**Shoalhaven Starches - Gas Pipeline (MP10_0144-Mod-1)
Request for Additional Information**

I refer to the modification request for Shoalhaven Starches – Gas Pipeline (MP10_0144-Mod-1). The Department of Planning, Industry and Environment (Department) has reviewed the modification request. After careful consideration, the Department is requesting that you provide additional information that effectively addresses the issues in **Attachment 1**.

ATTACHMENT 1
Department's Comments

P10

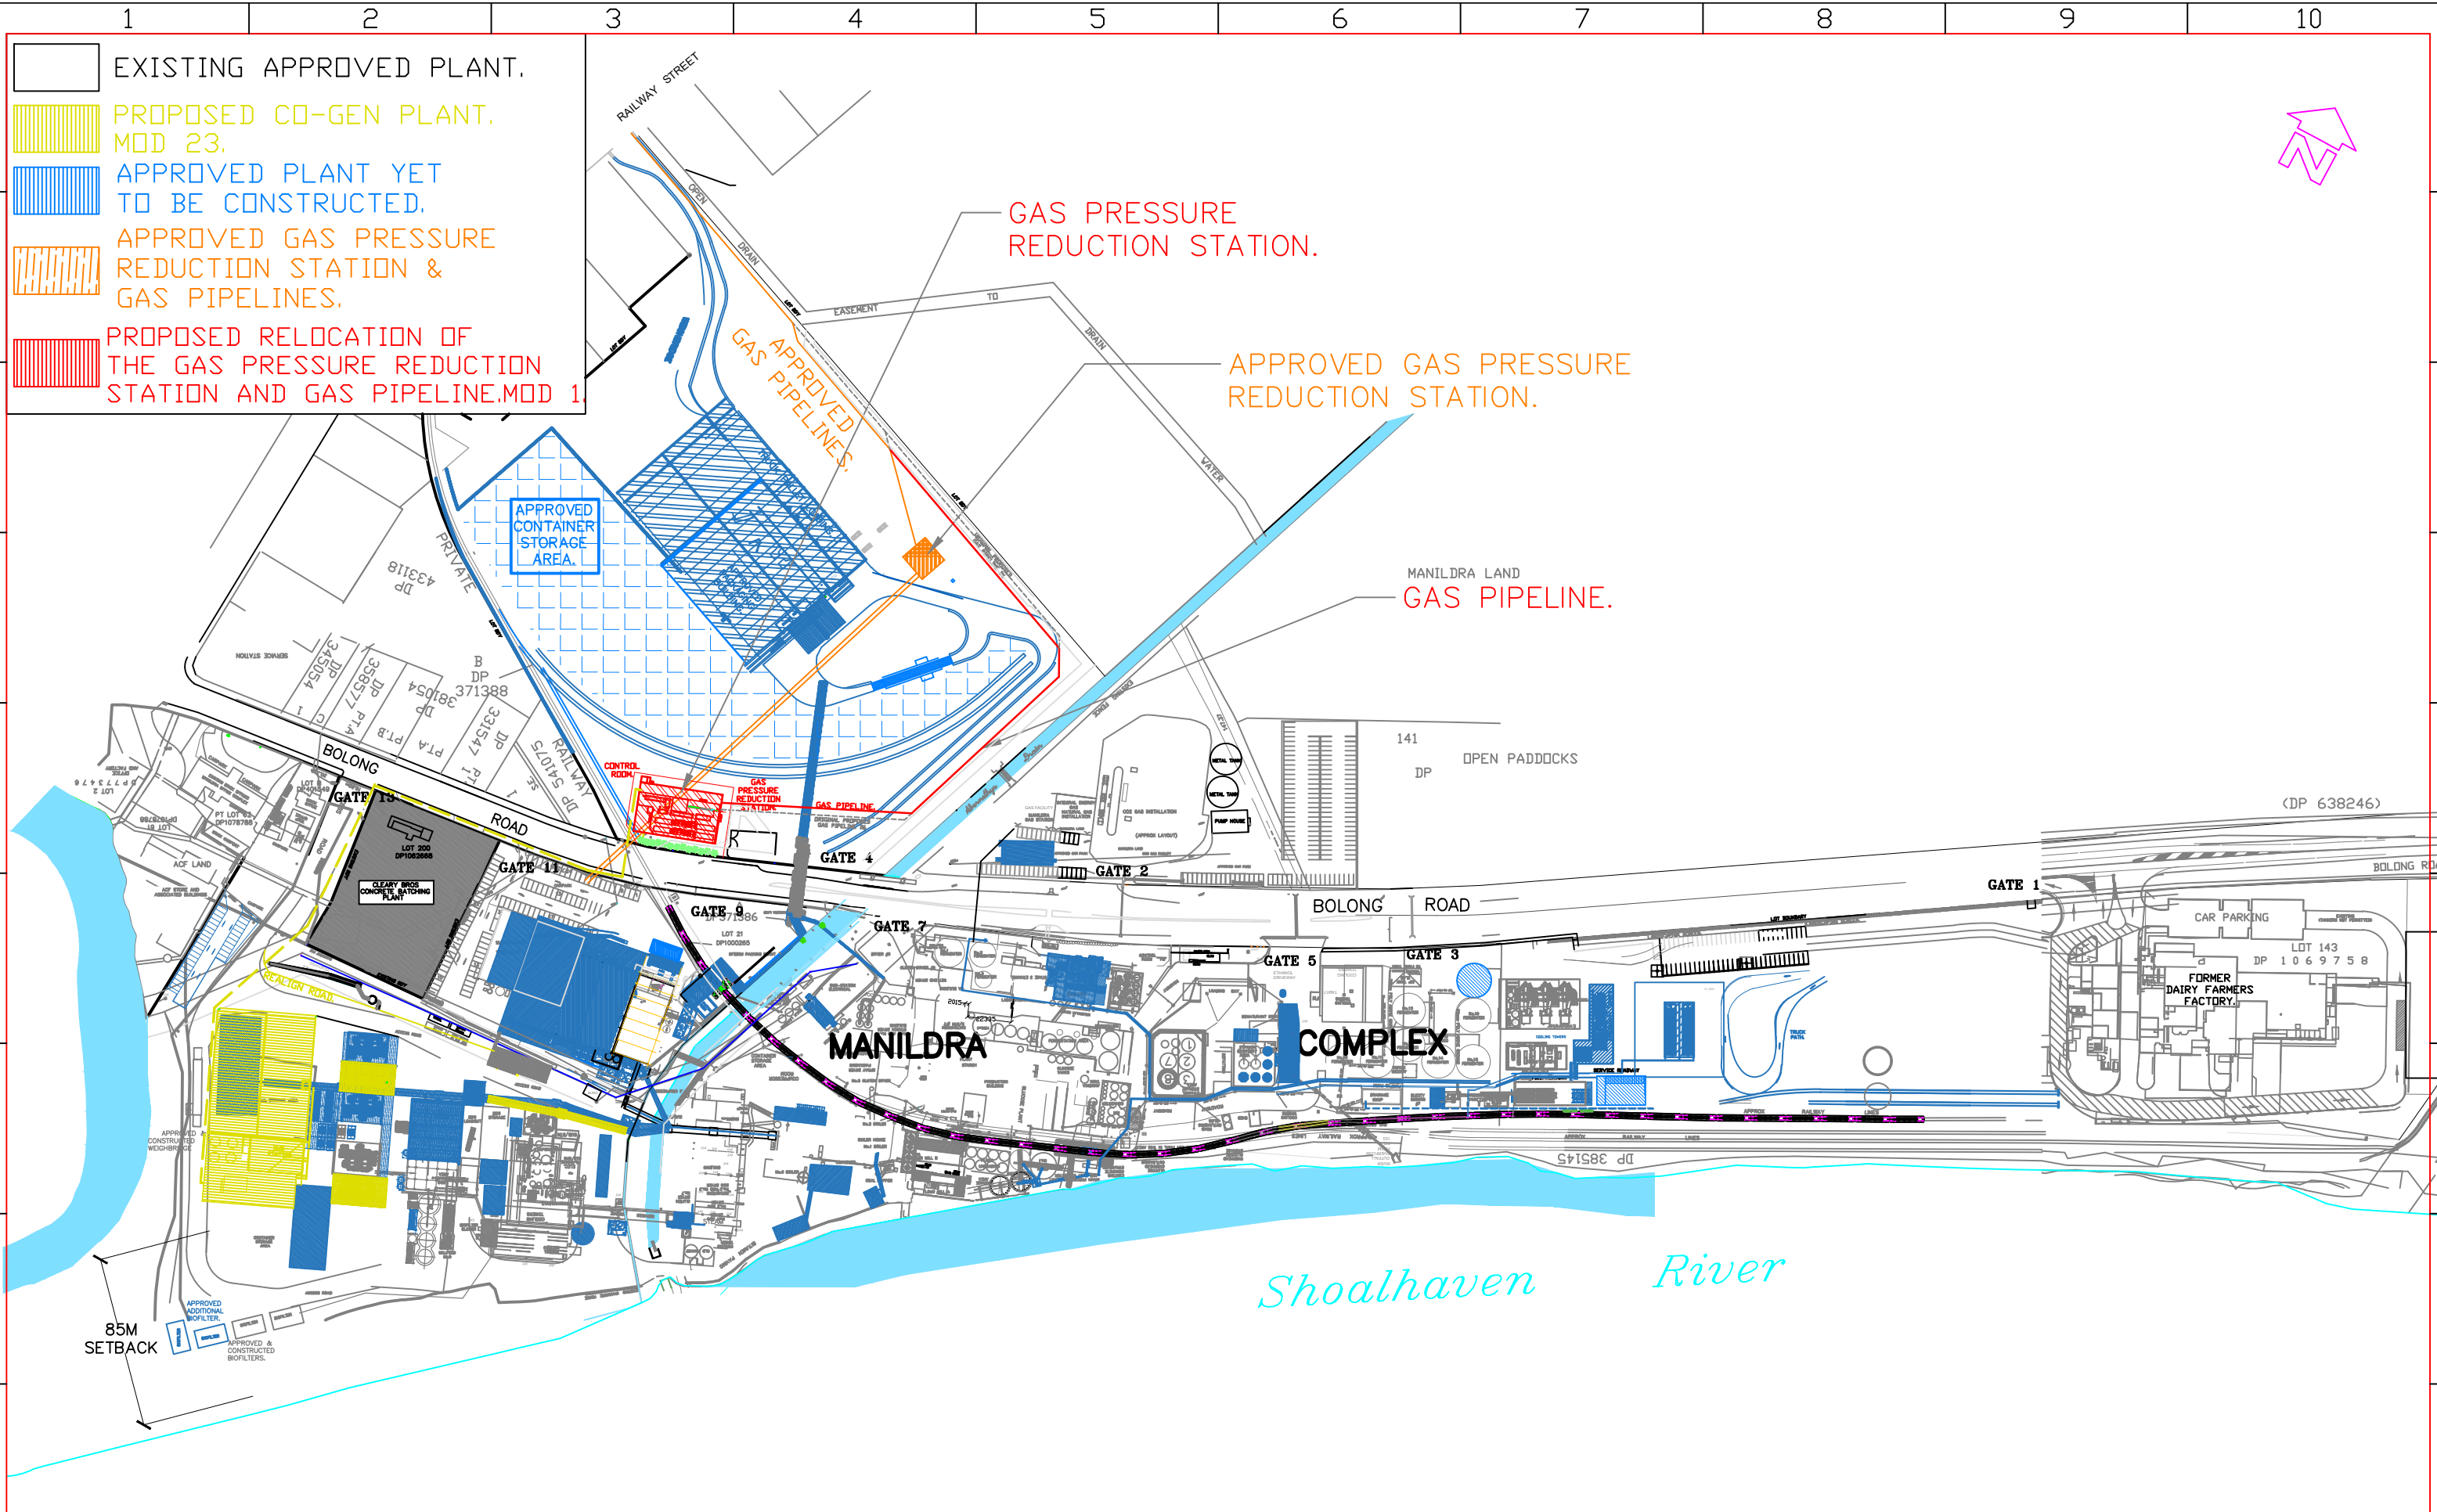
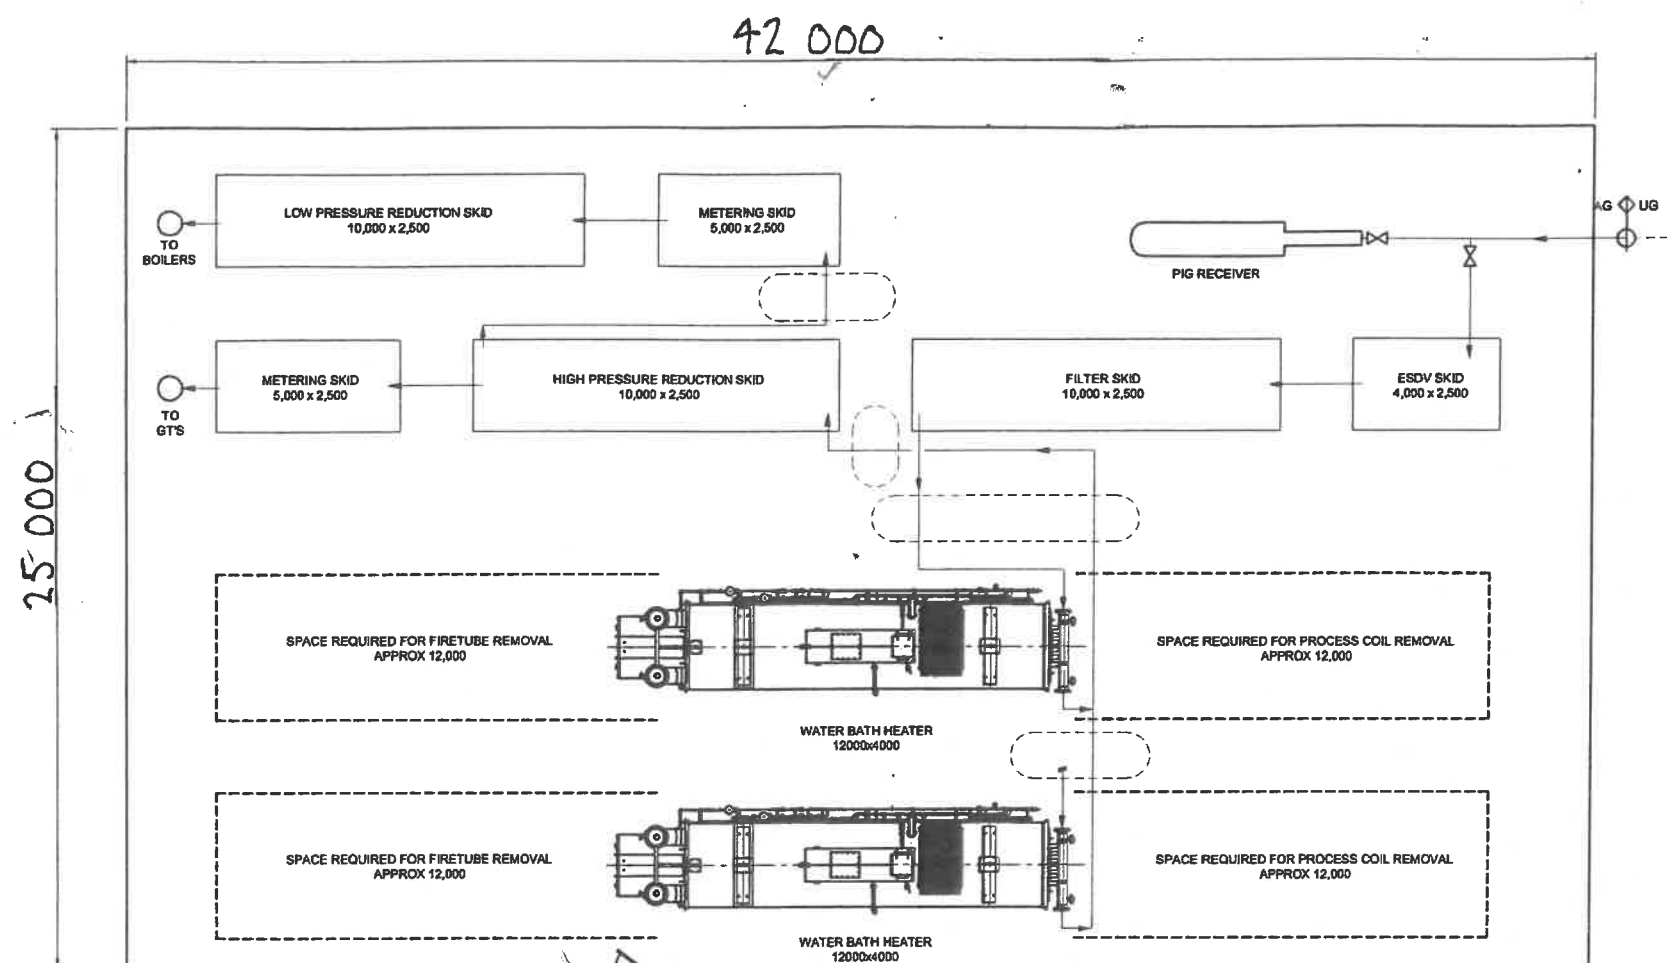
4. The relocation of the Gas Pressure Reduction Facility (GPRF) closer to Bolong Road decreases the separation distances to surrounding areas. Noting that the GPRF is now closer to the distillation plant, the PHA must demonstrate that the consequence of events associated with the GPRF meet the risk criteria in Hazardous Industry Planning Advisory Paper No.4 and that propagation risks are met.
